PLANNING & INFRASTRUCTURE
Planning Unit

SSD-13475973 STATE SIGNIFICANT DEVELOPMENT – MOWBRAY ROAD DATA CENTRE – 706 MOWBRAY ROAD, LANE COVE NORTH

Willoughby City Council

Figure 6: Indicative location of the diesel storage tanks

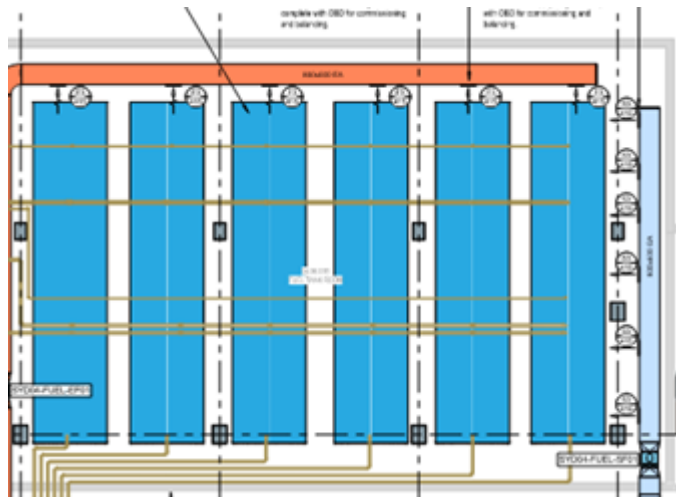
There is also a proposed total of six (6) bulk fuel tanks and 13 day tanks with a total of 402.6 kL or 342.2 tonnes of diesel fuel associated with the arrangements for back-up power. The Proposal also includes provision for a total of 169 lithium-ion battery cabinets, with a combined weight of 48.8 tonnes. The proposed development was found to be below the threshold for classification as potentially hazardous industry in terms of both storage and transportation and therefore a preliminary hazard analysis is not required.

Council is however concerned regarding the storage of fuel on site due to its location close to residential areas and a childcare centre. Council notes that alternative energy sources to diesel fuel were investigated, such as solar power and battery storage options being assessed for the proposal. The assessment found that diesel fuel is considered the most appropriate solution to meet the data centre demands however this would seem to be a poor choice and a regressive conclusion, out of step with the State's ambitions to move to net zero emissions by 2050.

**Figure 2 Height Plane Diagram from the Southwest Aspect** (Source: Greenbox Architecture, 2022)

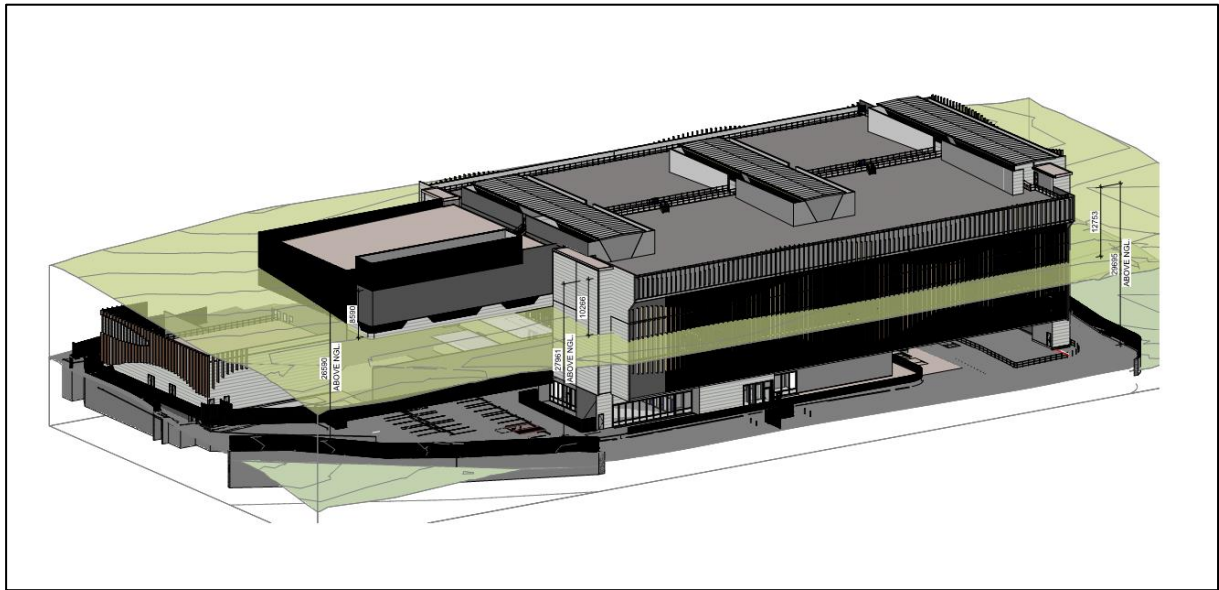
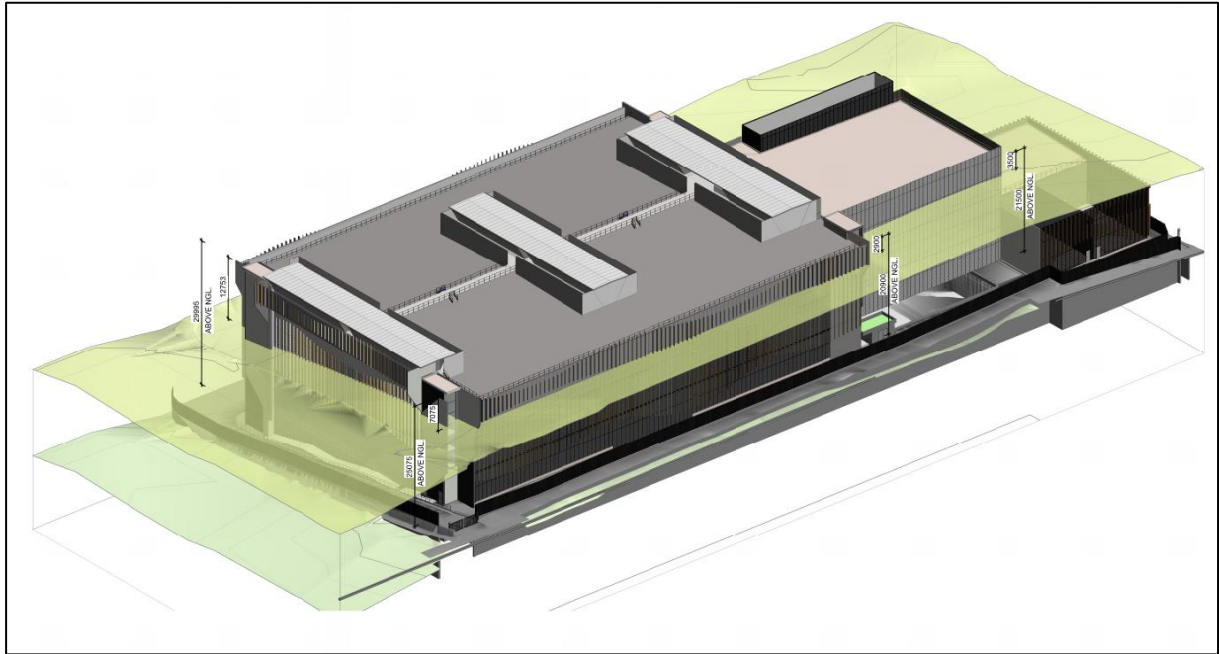
Council is concerned that the height of the proposed development varies in height from 20.9 m to 29.695m across the site. Concerns also include the proposed bulk and scale of the proposed building which is in close proximity to low density residential areas. It is noted that this is a significant variation from the 18m height limit under the Lane Cove LEP for the IN2 Light Industrial zone.

Figure 4 Proposed Northern and Eastern Elevations (Source: Greenbox Architecture, 2022)

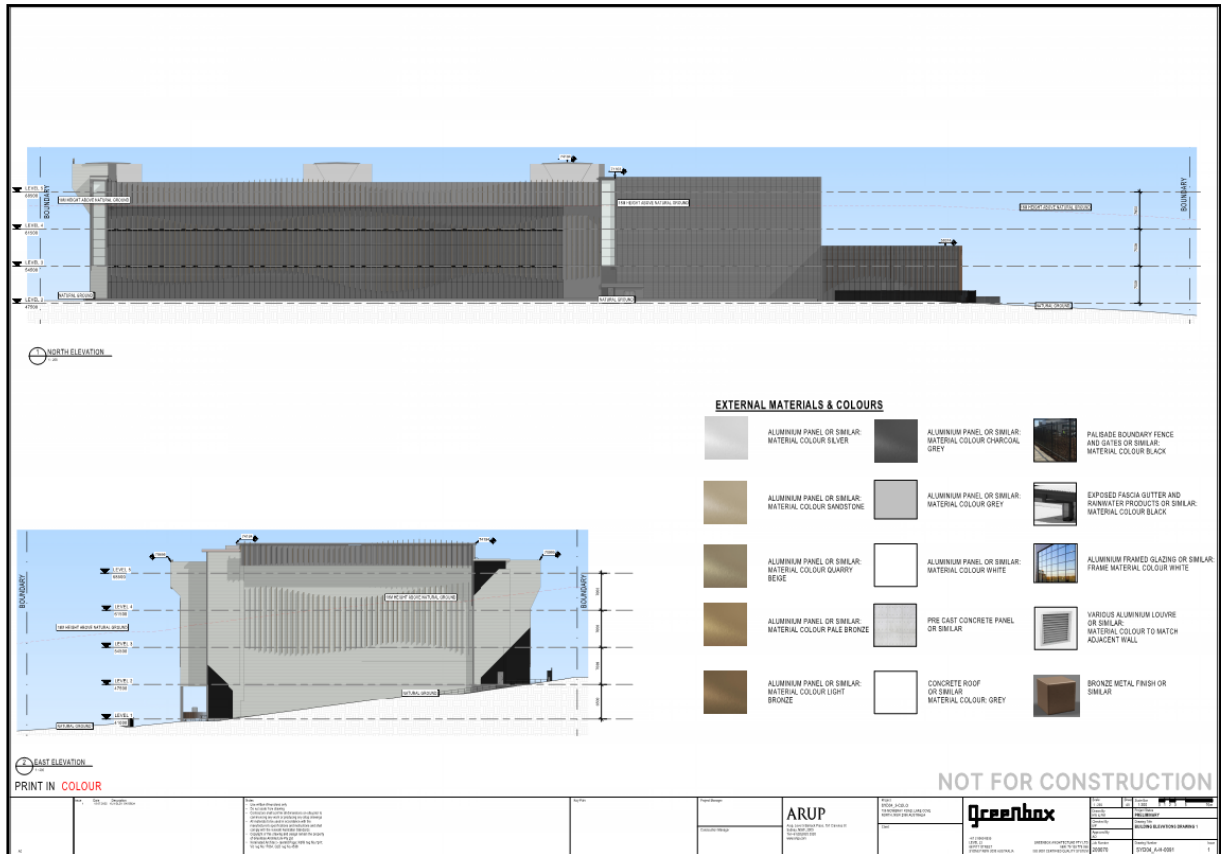
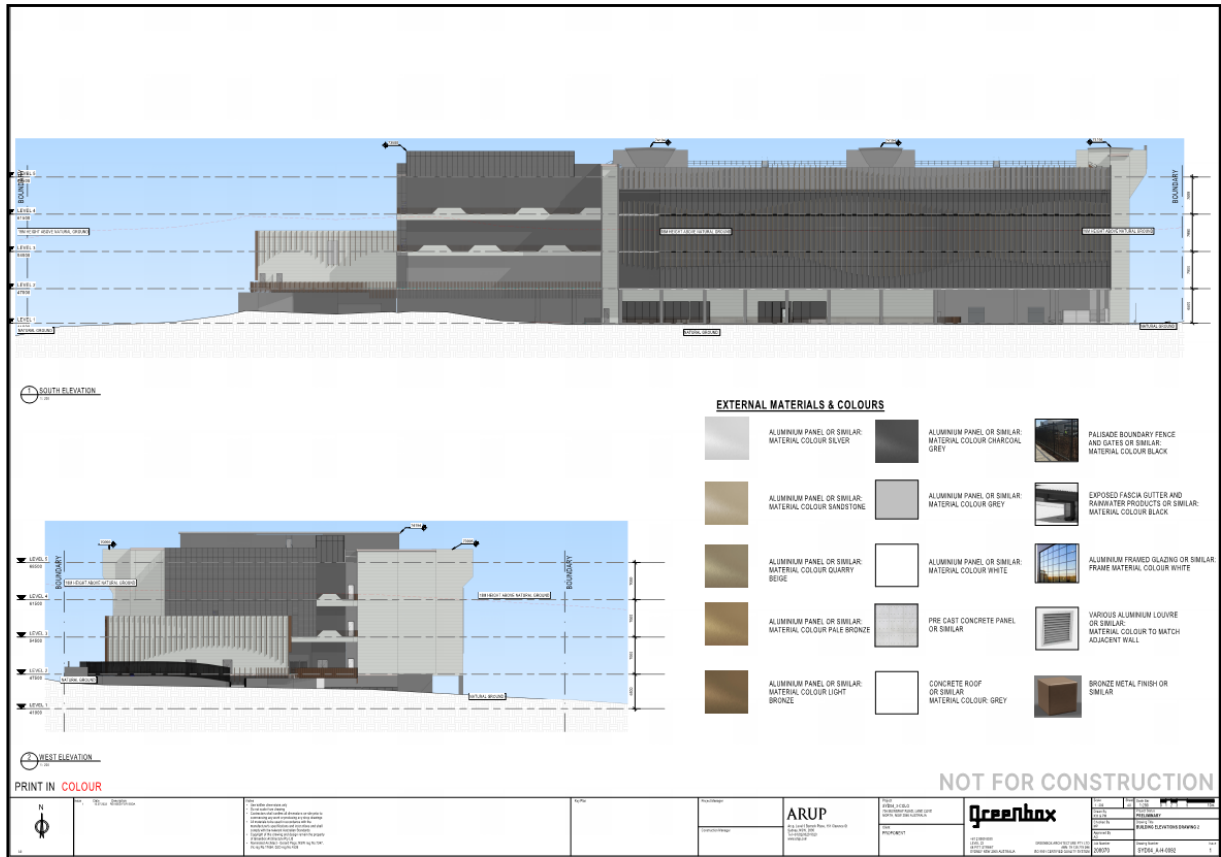
The Environmental Impact Statement (EIS) states that the architectural design proposes a uniform and flat roof for each major part of the overall building, which will conceal the proposed plant and equipment., It also states that the building will attain a height of 20.9 m closest to Mowbray Road West and 29.695 m to the rear of the Site at the highest point. While this is a reduction of the previously proposed maximum height of 38m, it is still considered that it will have a significant visual impact on nearby residential areas. The building bulk, scale, design and colours is a significant concern to the Council and local residents. It is considered that the building could be constructed with greater visual interest and provide some colour and material variation and other innovations such as green walls could be considered to reduce its visual impact and dominance in the neighbourhood. The

It is noted that there appears to be no opportunity for any planting along the eastern façade of the building, leaving a large blank wall visibly evident from surrounding streets and residences.
